05 November 2021

**Erection of 36 residential dwellings, along with landscaping and associated site infrastructure on land at Neddy Lane, Billington, BB7 9LL**

We refer to your letter of objection dated 22 October 2021 addressed to Ribble Valley Borough Council and enclose a series of comparative floodplain images, for each 0.2m slice considered, which we trust better illustrates the compensation proposals and demonstrates that a direct compensatory storage scheme is largely proposed.

Proposed Flood Plain Compensation Scale 1:250

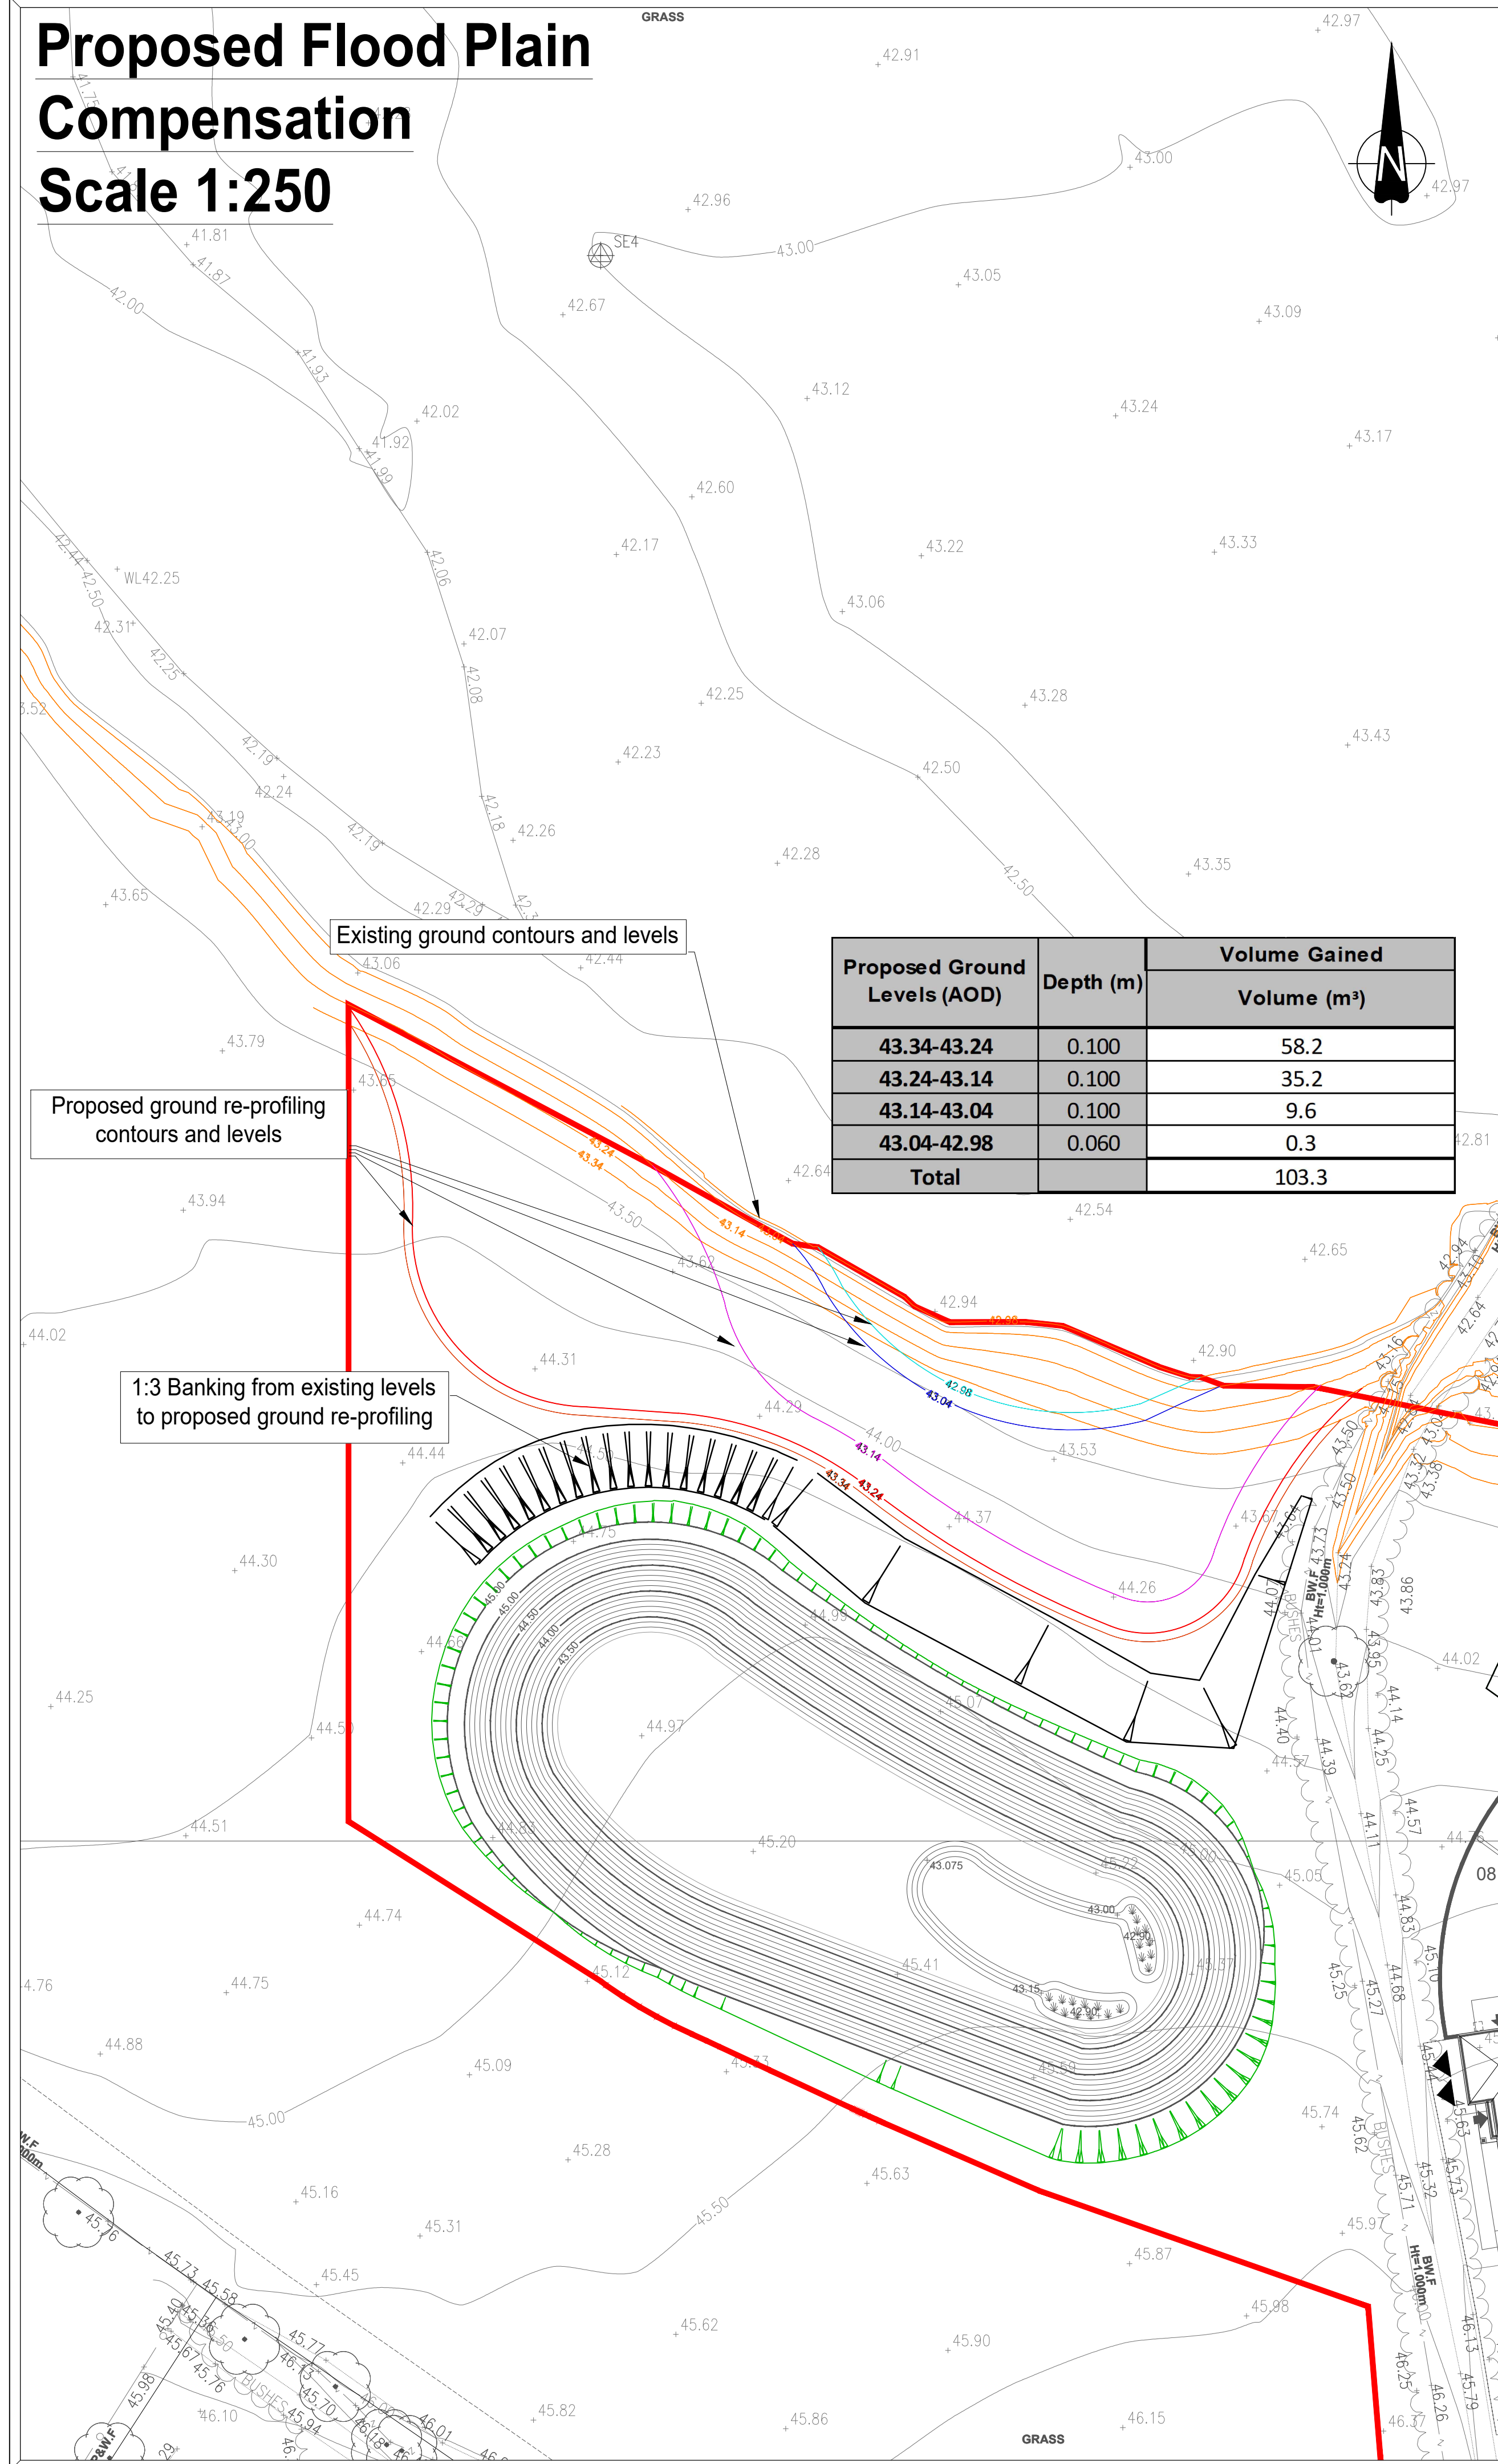
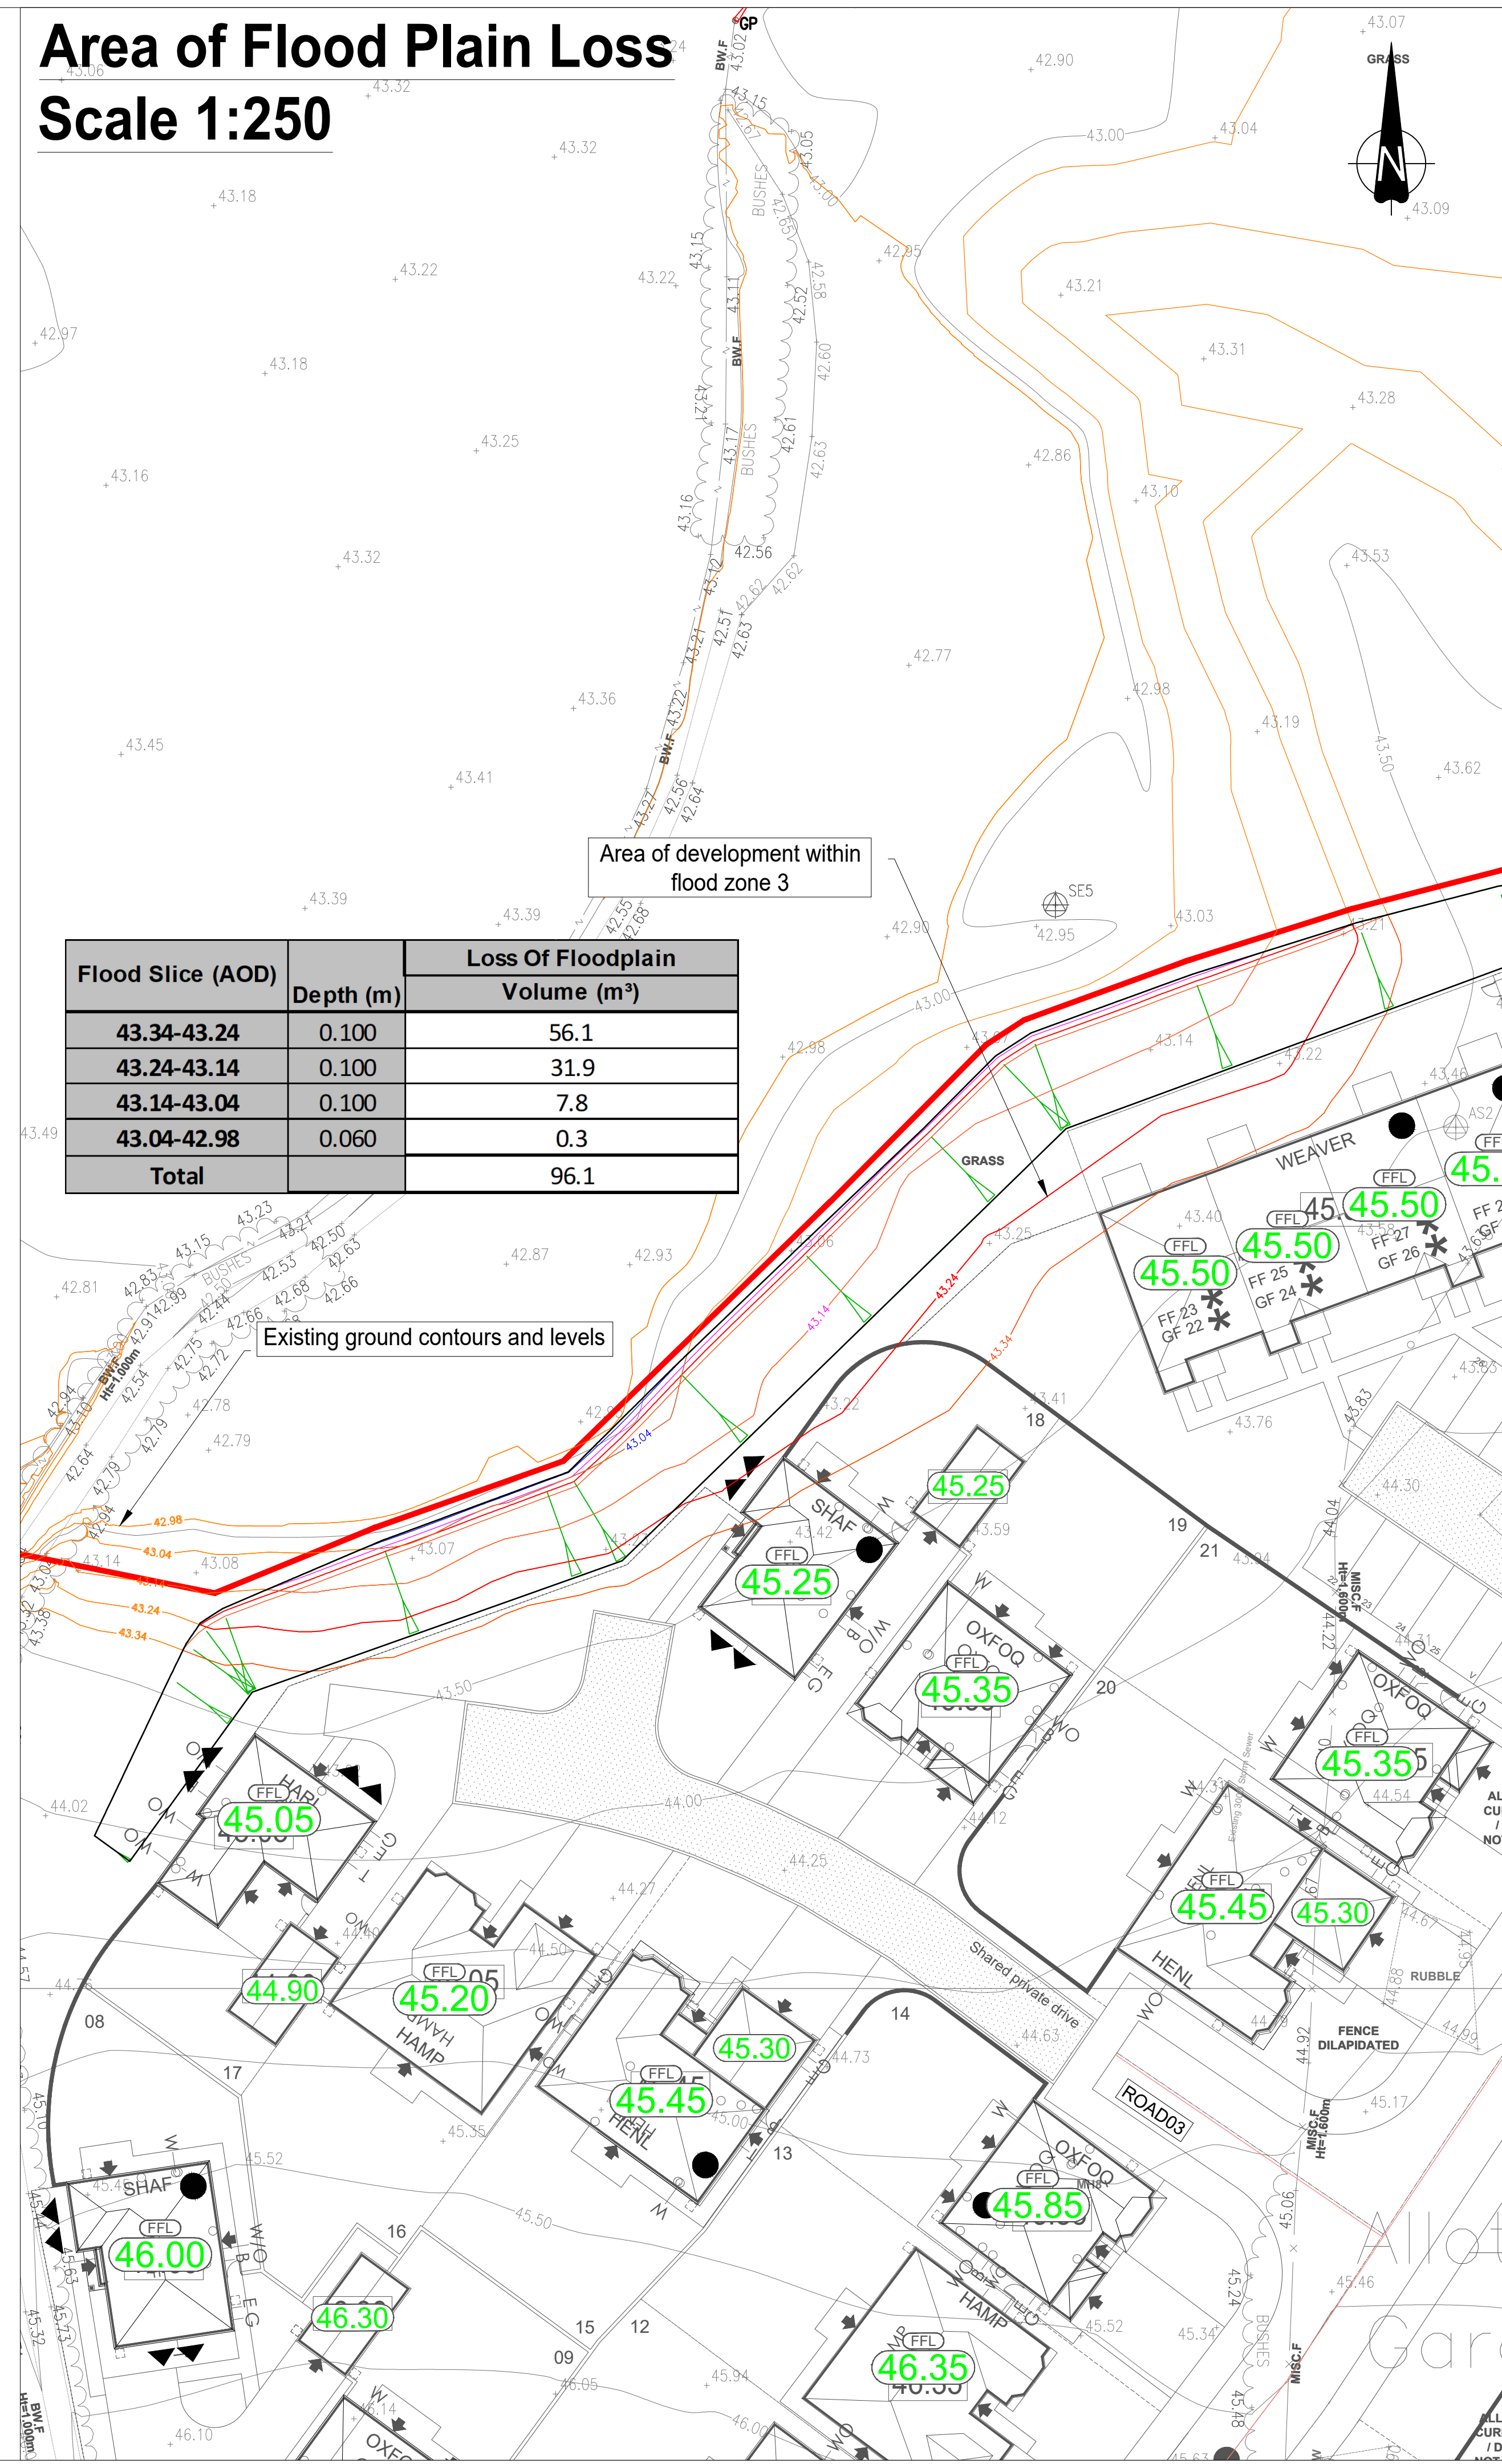
The recontouring of land immediately adjacent to the existing floodplain is proposed for events up to 44.58mAOD (approximately the 1% AEP + 15% return period). For greater events a short channel linking the floodplain is proposed. There are two primary reasons for this:

1. There is insufficient land available to provide compensatory storage to the north of the public footpath crossing the land.
2. To limit the extent of vegetation/hedgerow removal alongside the public footpath to facilitate compensatory storage area.

Whilst we consider there may be opportunities to further refine the proposals to resolve any concerns regarding the linking channel, which could be considered at the detailed design stage, we believe the scheme as proposed offers compensatory storage as close as is reasonably possible to the existing floodplain.
